Application No: MP07_0158 MOD 3

Exhibition of Modification Request for the University of Sydney Abercrombie Precinct Redevelopment

Date: 1 November 2013

Name: Robert Britton

Title
Scale
Date
Number
0 2 4
10 20m
Ground Floor Plan
MARK UP SET
1:200@A1
11.10.13
4001_DA02-D
© copyright nettleton tribe partnership pty ltd

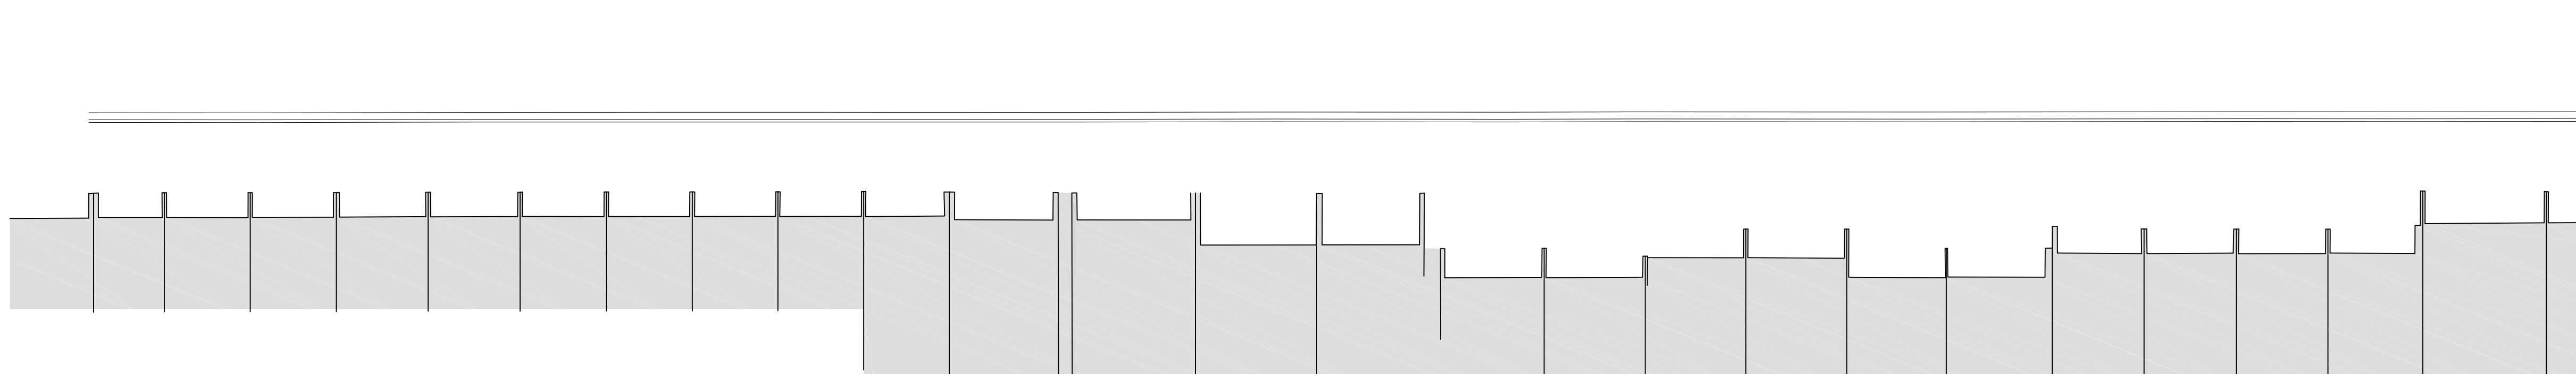
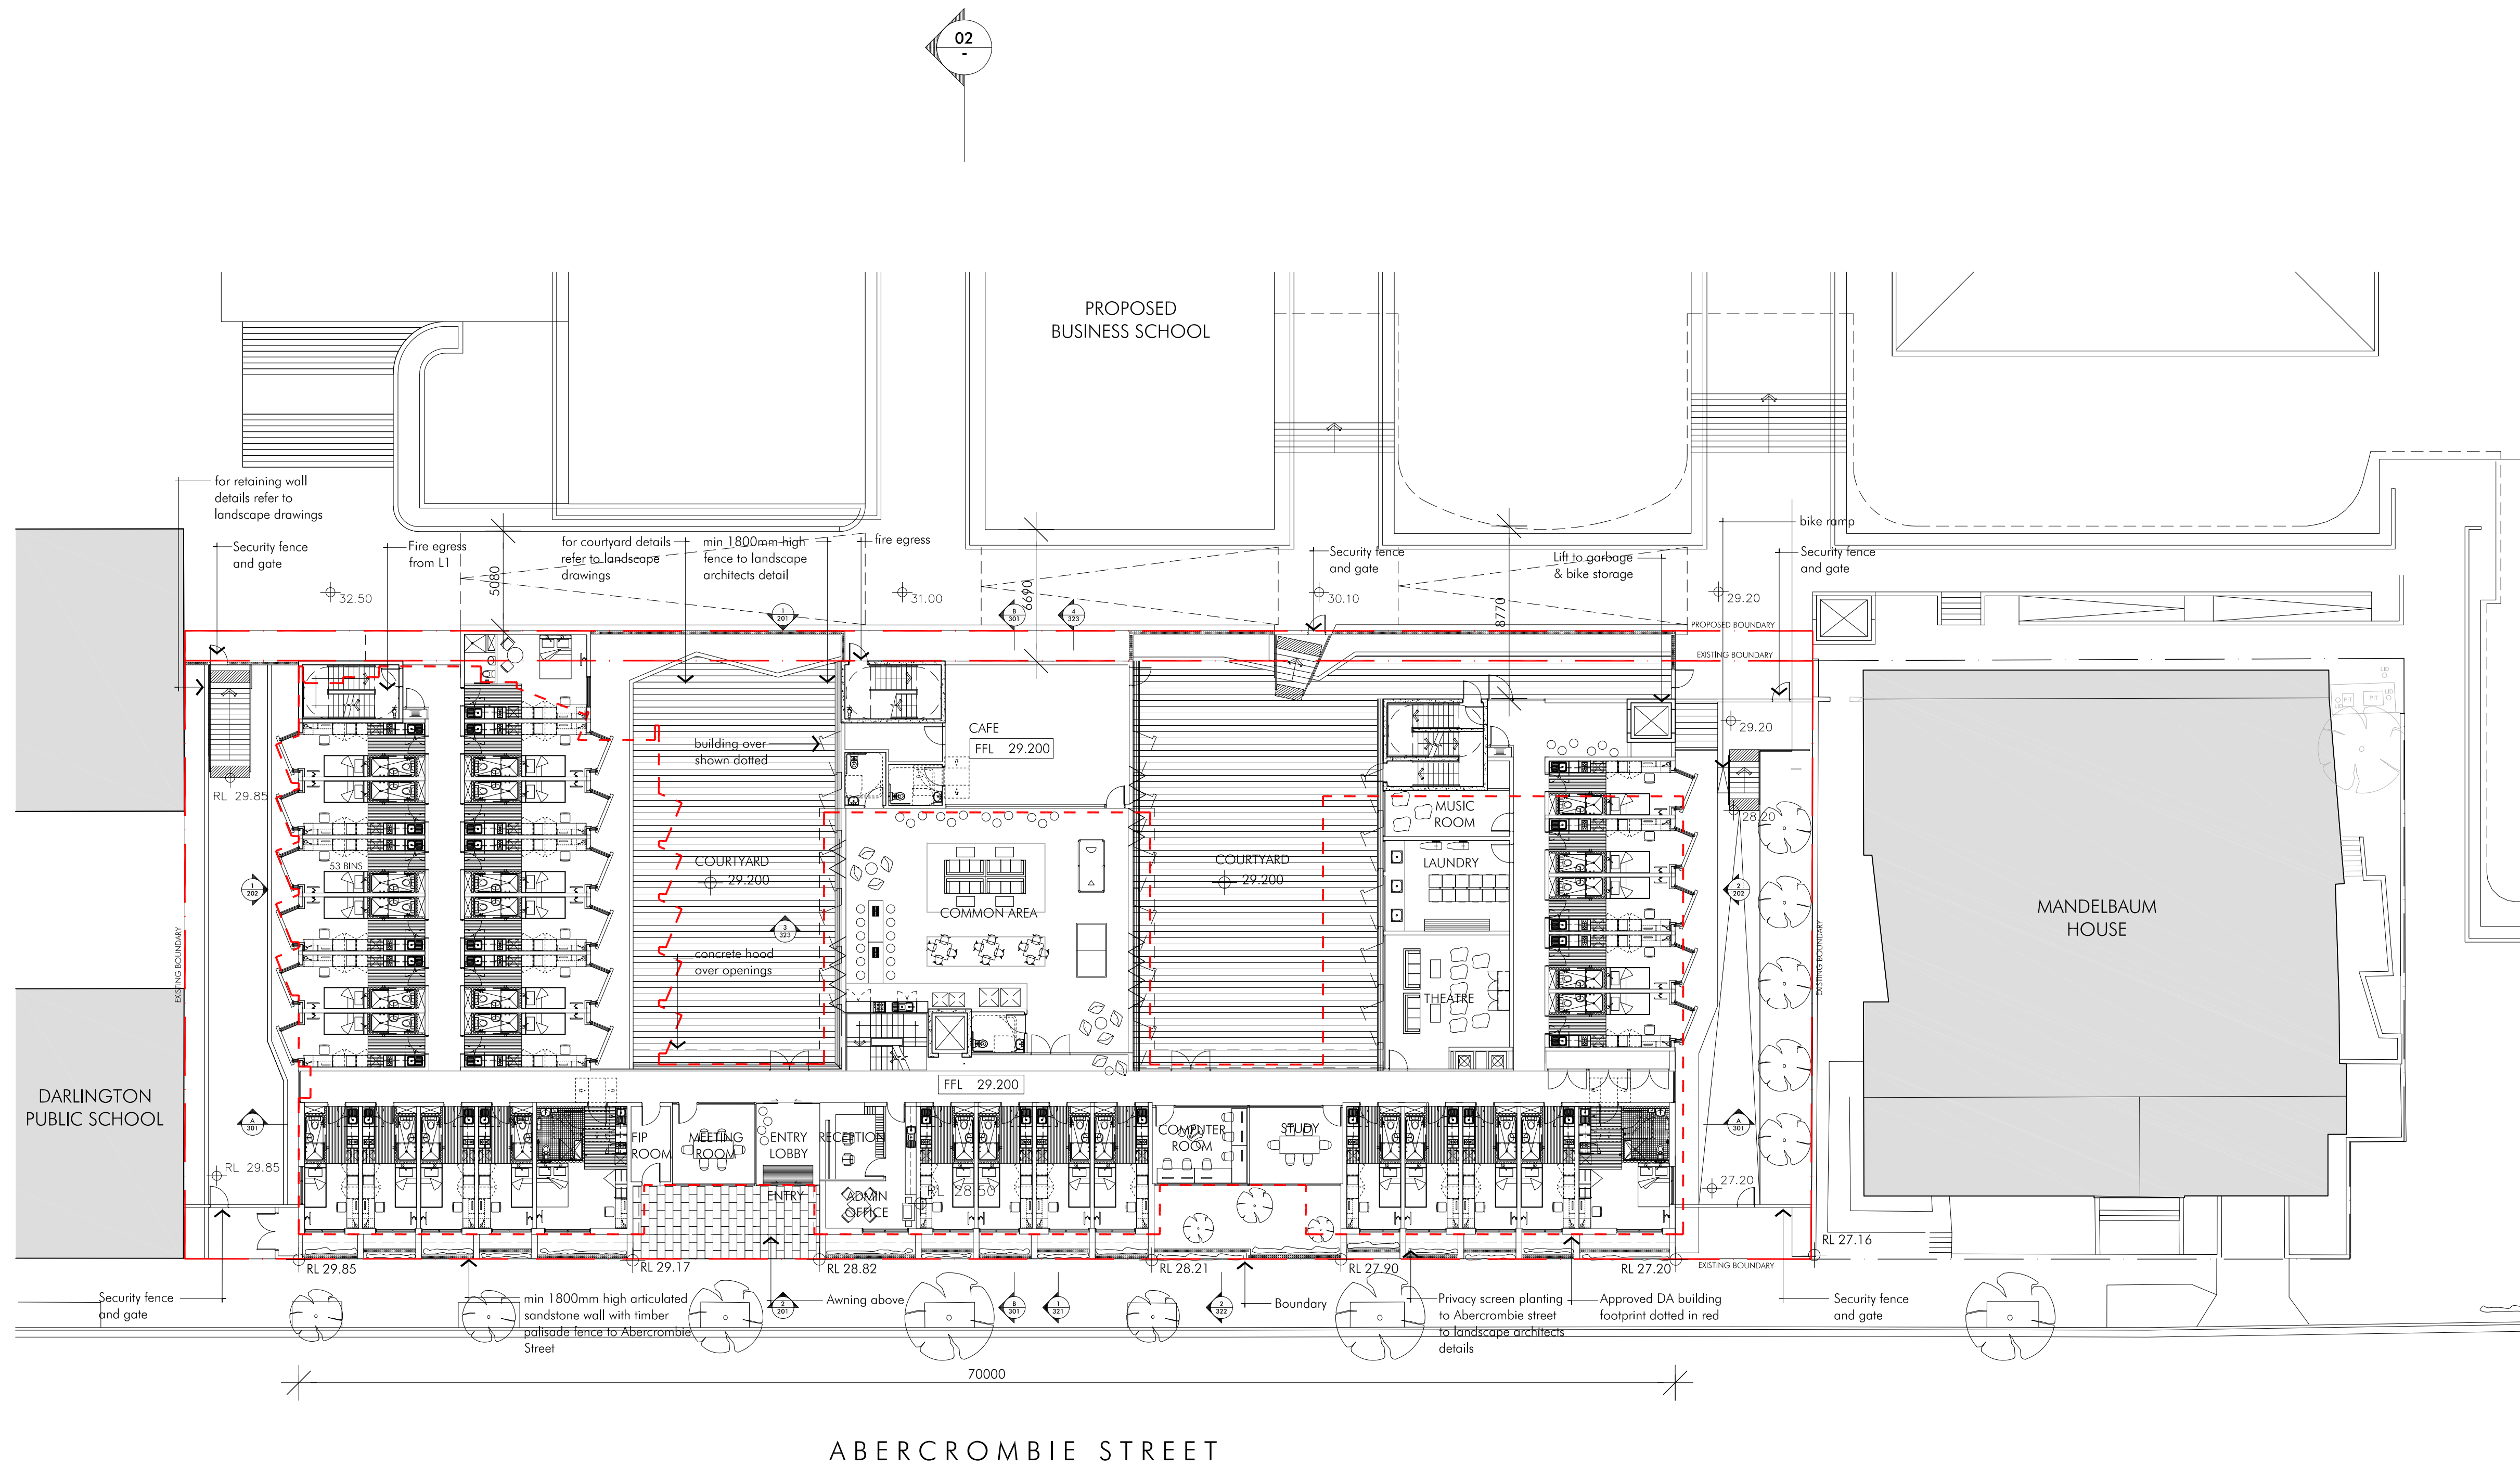
These original plans for the APD and Student Accommodation show that the front of the Student Accommodation would be built in line with Mandelbaum House on the Abercrombie Street side. See pictures below.

We believe that the Student Accommodation should also be set back from the front boundary by 2 metres and built in line with Mandelbaum House. Once again there should be no exceptions for the University owned building and it should be made to comply as other buildings have along Abercrombie Street. It should also be contained within the same footprint as those buildings being demolished to make way for it.

The latest plans for the Student Accommodation, whilst showing the front of the building abutting the boundary on Abercrombie Street, also show an increase in floor area at the back towards the Business School.

The whole building should be moved back to align with Mandelbaum House as it was originally planned and presented to the residents - see above pictures. There should be no increase in floor area at the back and the number of students living in the facility should be restricted to the originally approved 188 or to an even lesser number. The number of students should not be increased to 200 as is now proposed.

Access pathways are proposed for either side of the new Student Accommodation running from Abercrombie Street into the APD at the back of the Student Accommodation.

The areas at either side of the proposed Student Accommodation should be kept as green areas. The provision of heavily landscaped buffers at each end of the Student Accommodation will discourage students and other groups from congregating at all hours bringing noise and disruption to residents living nearby as well as those living within.

Students living here will be able to access the University through the back of the building; therefore these access paths are not warranted.

The plans show a music room facing into Abercrombie Street. This room and any others that would have loud noise and are places where students will gather in numbers must be sound proofed protect the amenity of residents.

02 ELEVATION SOUTH (ABERCROMBIE STREET)
SCALE 1:200

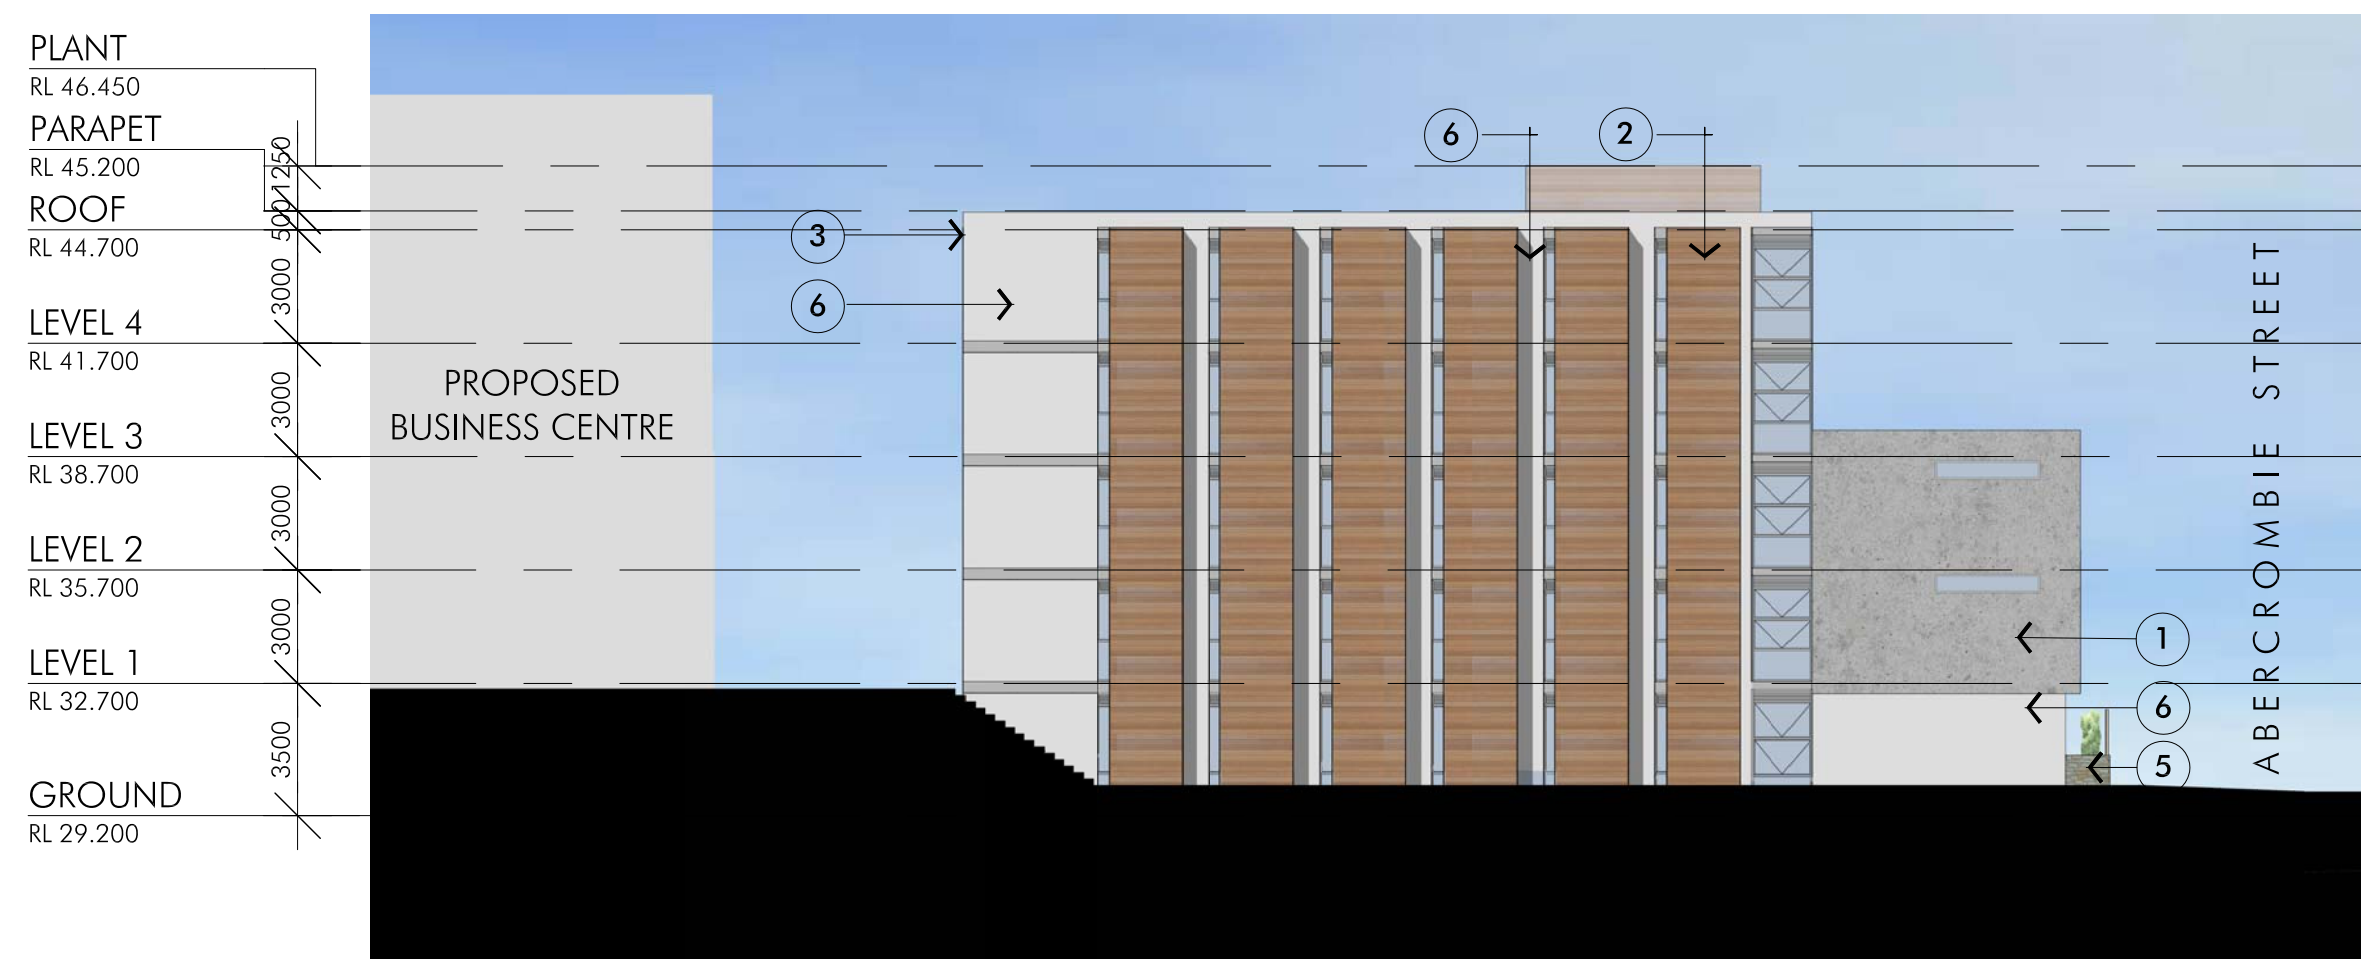
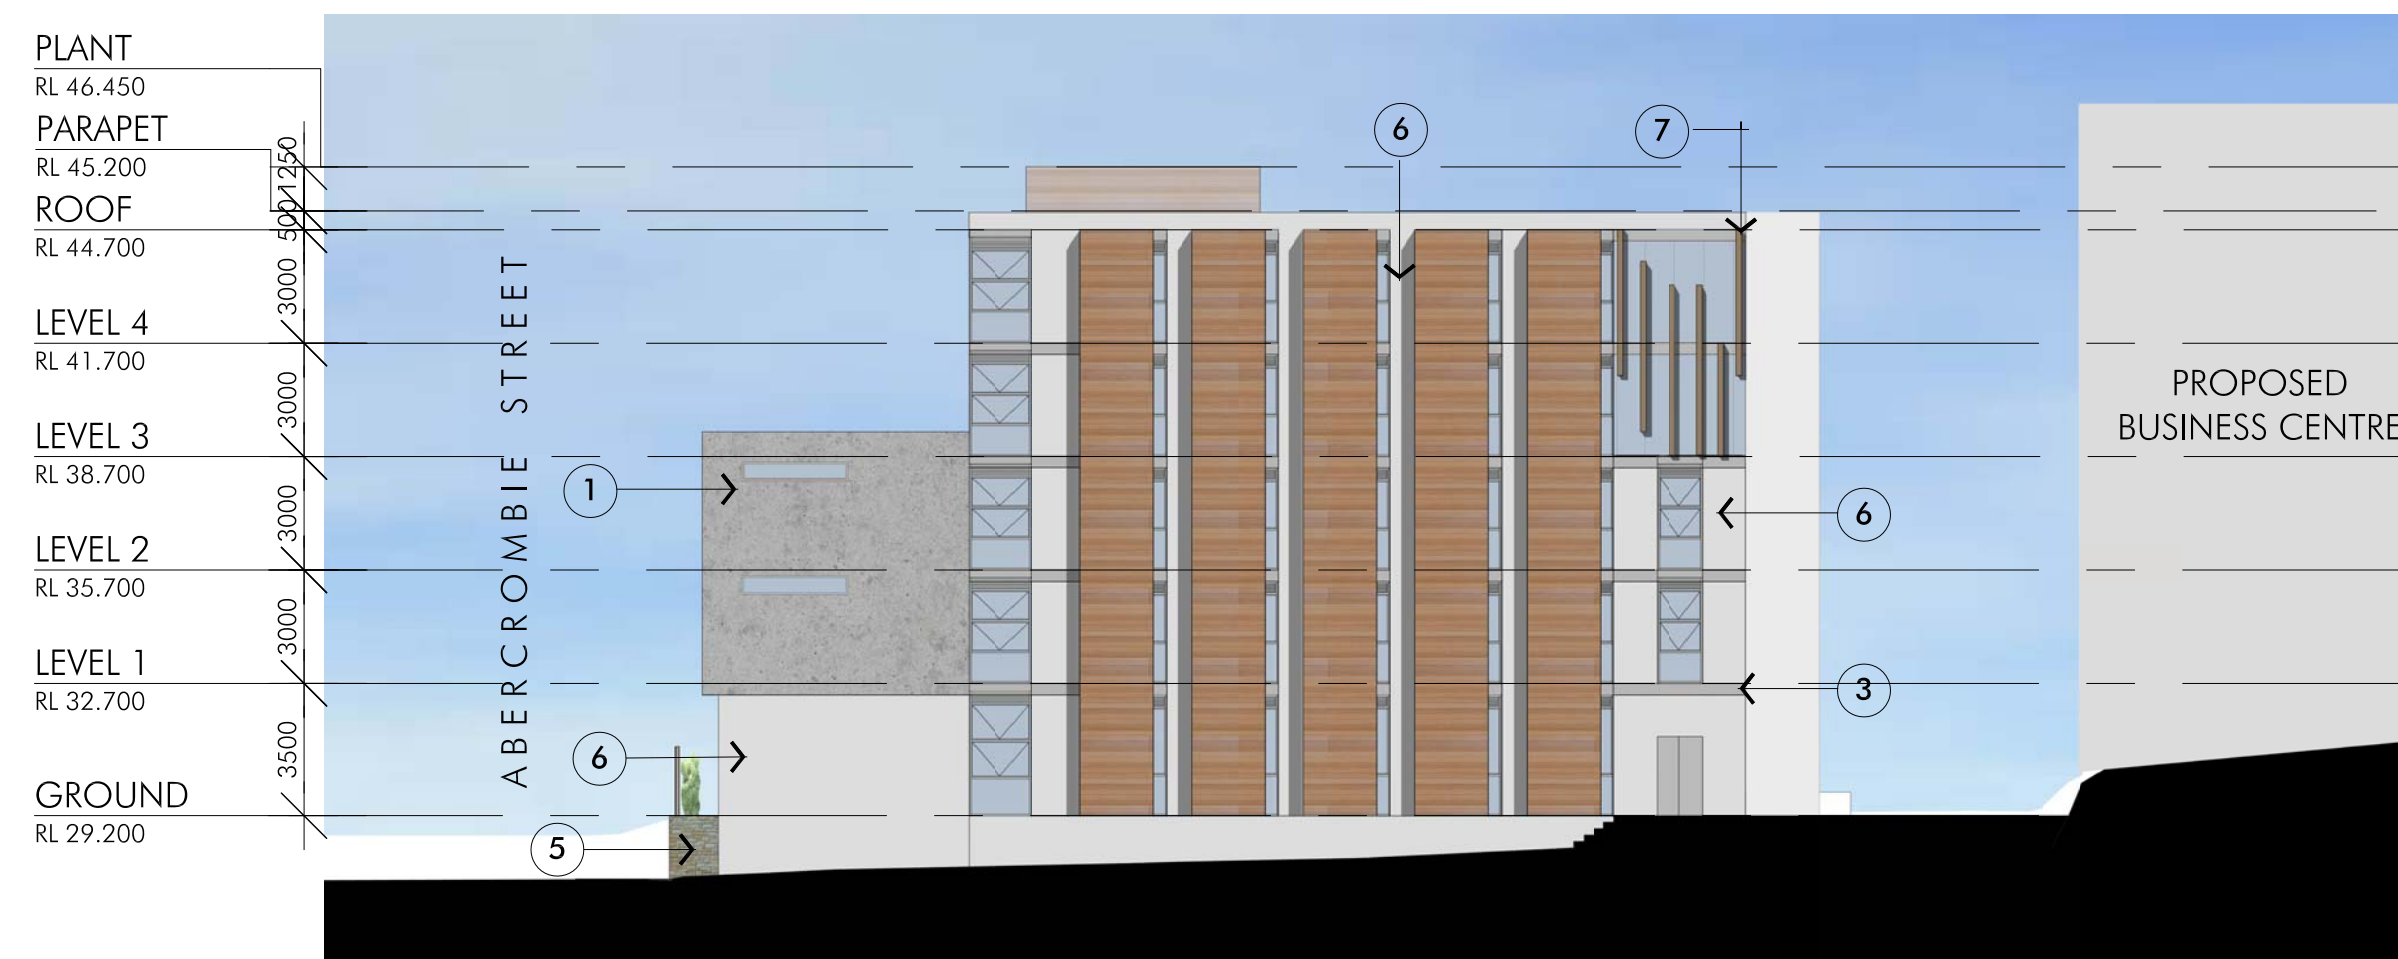
- The University's own elevation below clearly shows that Darlington Public School, outlined in red on the left of the picture, is a 2 storey building which sits well below the 5 storey Student Accommodation.
- The red line at the top of Mandelbaum House on the right of the Student Accommodation is actually the height of its pitched roof.

Many objections made to the original plans for the APD Business School and Student Accommodation buildings were on the basis of their height, bulk and scale, especially as they are proposed to stand much higher than Mandelbaum House to the east and Darlington Public School to the west, dwarfing both of them.

The scale of the proposed Student Housing building along Abercrombie Street is up to five storeys, which is out of character with the prevailing height and scale of the 2-3 storey Victorian terraces on the southern side of Abercrombie Street and a number of other traditional buildings mainly located at the intersection between Abercrombie Street and Codrington Street.

- The building should be reduced in height and scale so that it is consistent in height with Mandelbaum House and conforms to the established 2-3 storey characteristic height of buildings along Abercrombie Street.
